Appeal Decision

Appeal Ref: 6005832

Woodfold Park Stud, Woodfold Park, Mellor, Lancashire BB2 7QA

- The appeal is made under section 78 of the Town and Country Planning Act 1990 (as amended) against a refusal to grant approval required under Article 3(1) and Schedule 2, Part 1, Class A of the Town and Country Planning (General Permitted Development) (England) Order 2015 (as amended).
 - The appeal is made by Mr Chris Ellison against the decision of Ribble Valley Borough Council.
 - The application Ref is 3/2025/0899.
 - The development proposed is rear single-storey extension to detached dwellinghouse.
-

2 Proposed Rear Elevation
Scale 1:100

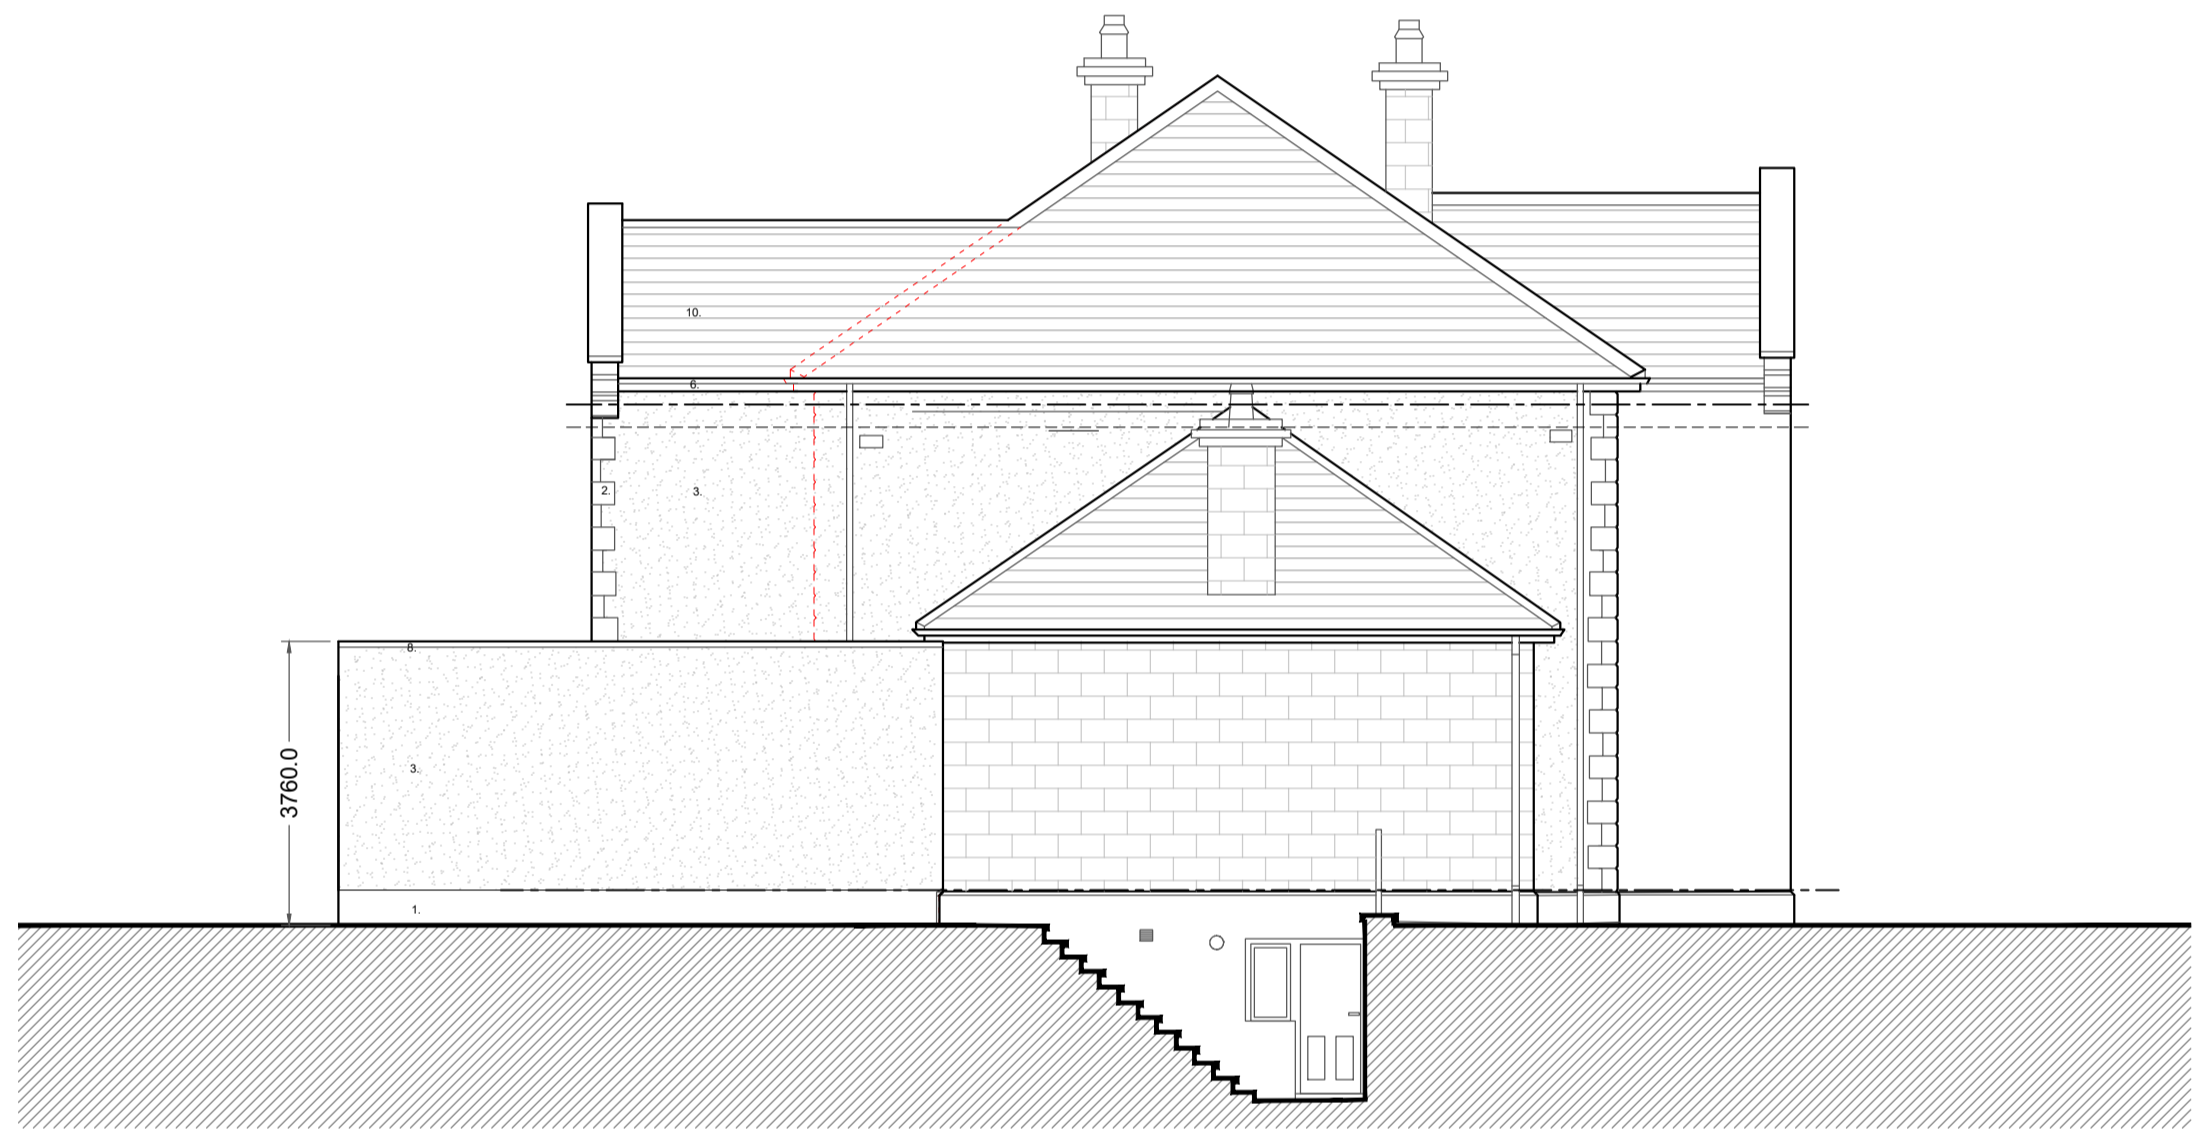
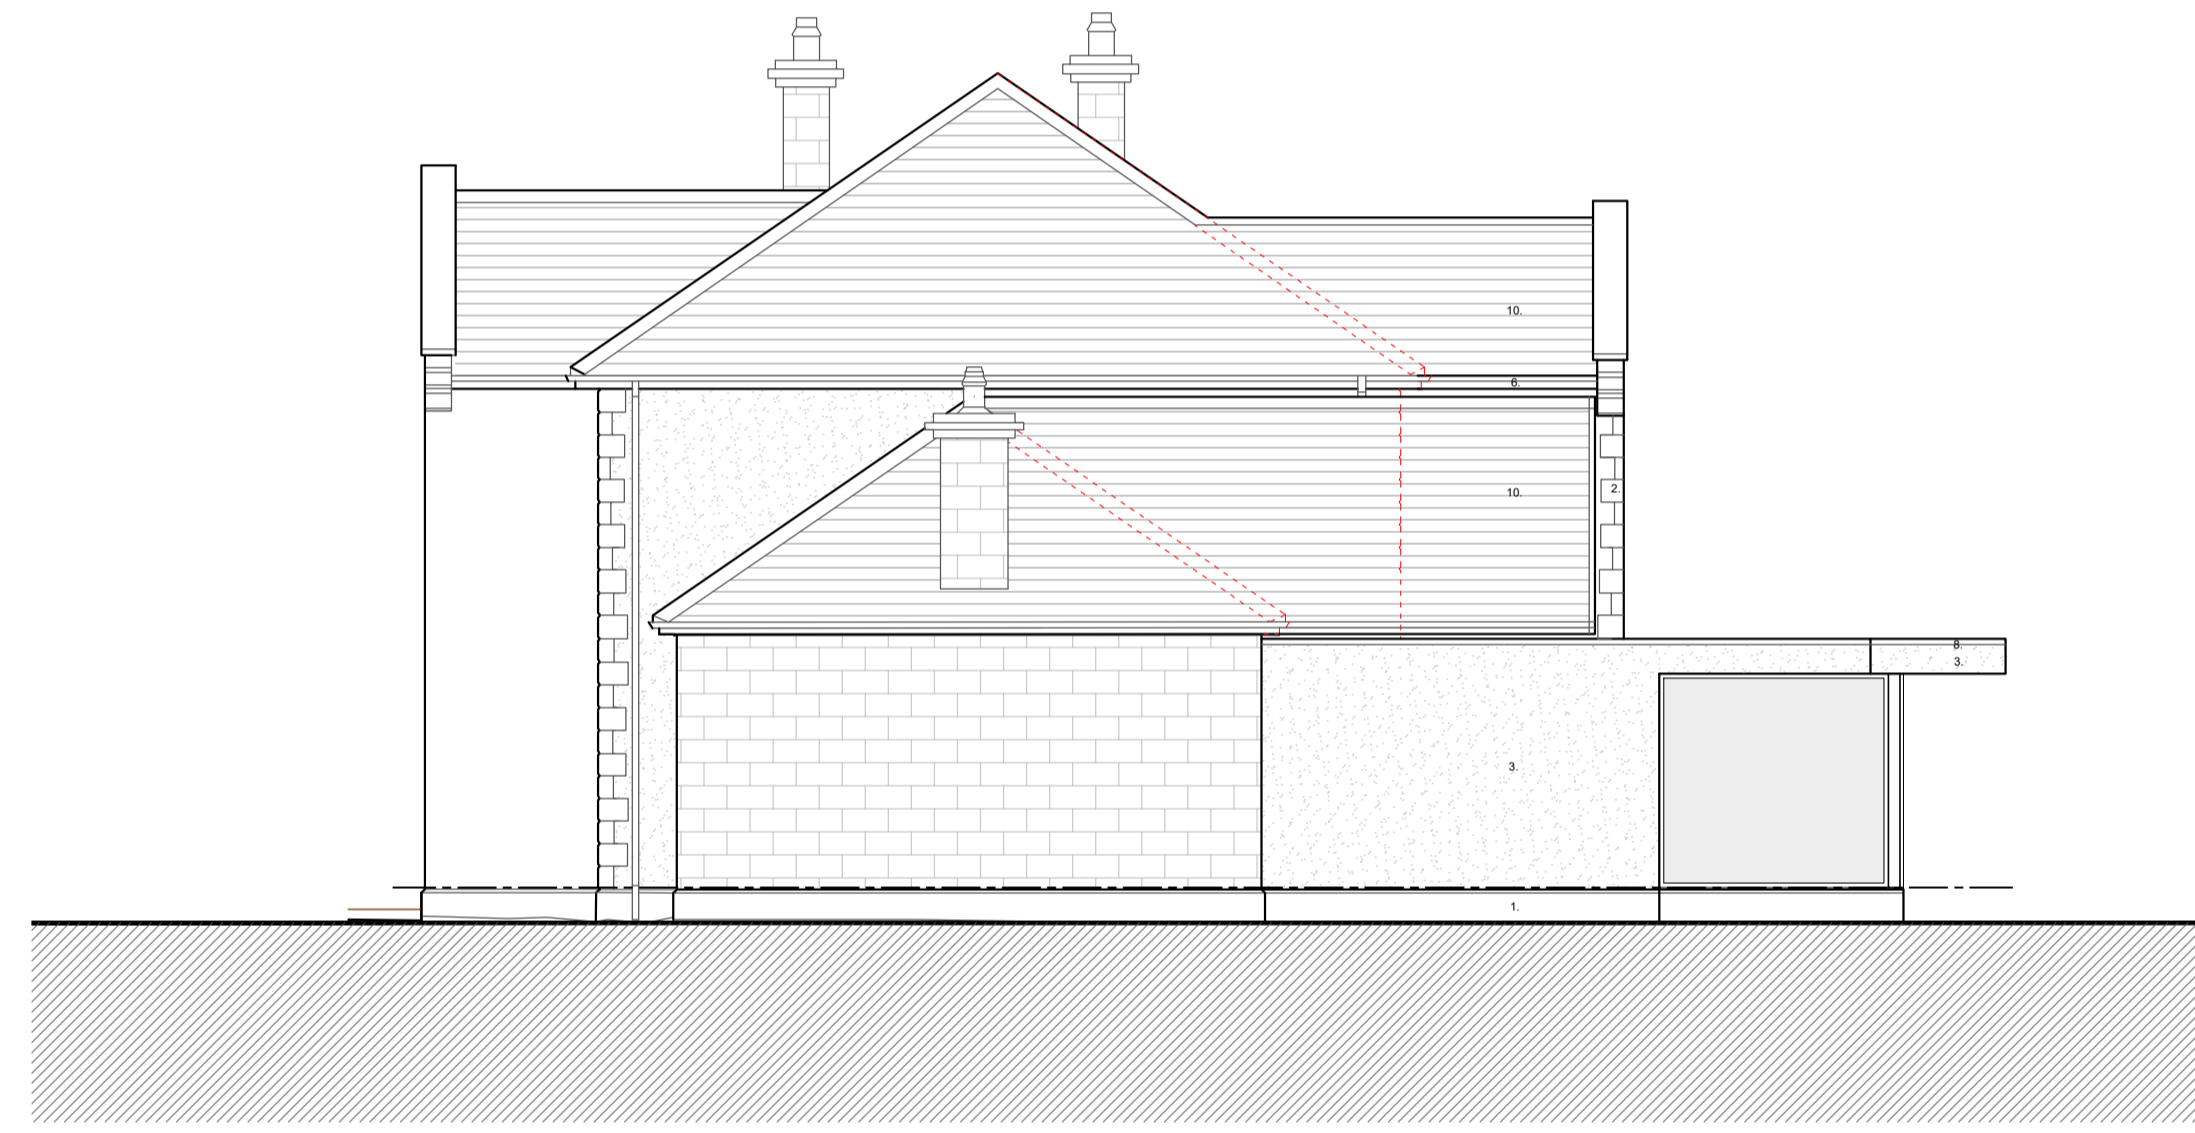
6. The appeal property is a large, detached 2-storey dwelling with a stepped rear elevation. The proposal relates to the erection of a single storey extension to the rear of the building. The submitted plans and application form show that the extension would project up to 8 metres beyond the rear wall of the original dwellinghouse, broadly following the staggered arrangement of the existing rear elevation.

8. Paragraph A.1(j)(iii) of the GPDO states that, where the enlargement would extend beyond a wall forming a side elevation, it is not permitted development if its width would exceed half the width of the original dwellinghouse. The Technical Guidance explains that any wall that cannot be identified as a front or rear wall should be regarded as forming a side elevation, and this can be more than 2 walls. The diagram on page 22 illustrates this approach. As the appeal property has a stepped rear elevation, it has several clearly identifiable side elevations.

10. Applying paragraph A.1(j)(iii) of the GPDO, and having regard to the interpretation set out in the Technical Guidance, the proposed extension would project beyond a number of side walls created by the stepped rear elevation, and its width would exceed half the width of the original dwellinghouse. The proposal would therefore fail to comply with this limitation and would not constitute permitted development.

11. Paragraph A.1(g)(i) states that, to be permitted development, a single storey extension must not extend more than 8 metres beyond the rear wall of the original dwellinghouse. The Technical Guidance confirms that this measurement should be taken from the base of the rear wall of the original house. Measured in this way, the proposed extension would not exceed the 8-metre limitation and would therefore comply with paragraph A.1(g)(i).

12. I conclude that, although the proposal would comply with paragraph A.1(g)(i), it would fail to satisfy the requirements of paragraph A.1(j)(iii) and would therefore not be permitted development under Class A.
